Item No. **Report of the Head of Planning, Transportation and Regeneration**

Address LAND AT THE REAR OF 12 WHITETHORN AVENUE YIEWSLEY

Development: Erection of a 1-bedroom bungalow with parking and amenity space.

LBH Ref Nos: **10697/APP/2021/4279**

Image -01

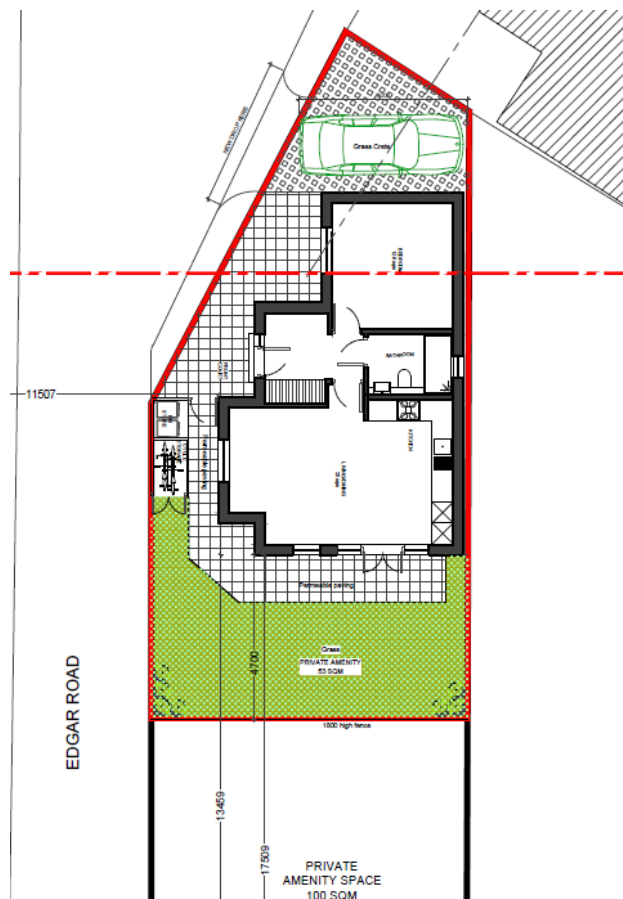
The proposed development, by virtue of the siting of the proposed 1.8 metre high fencing, bin store and cycle store in such close proximity to front habitable room windows of the proposed dwelling would result in a substandard form of residential accommodation to the detriment of future occupants, in terms of poor levels of outlook. The proposal would therefore be contrary to Policy DMHB 16 of the Hillingdon Local Plan: Part 2- Development Management Policies (2020), Policy D6 of the London Plan (2021) and the National Planning Policy Framework (2021).

The submitted elevation drawing shows that a 1.8 metre high fence is being proposed along the front and side boundaries of the site. At the closest point, the 1.8 metre high fence would only be separated from the front elevation window serving the open plan kitchen/living/dining room by some 2 metres. It is also noted that this would face directly onto the proposed bin and cycle stores. The windows and open glazed bi-folding doors fitted in the side elevation and serving the open plan kitchen/living/dining room would be positioned only 4.7 metres from the proposed 1.8 metre high fencing along the boundary of No. 12 Whitethorn Avenue. As a result, the future occupiers of the proposed dwelling would be provided with a poor level of outlook and would experience an oppressive and unwelcoming sense of confinement to the detriment of their living conditions.
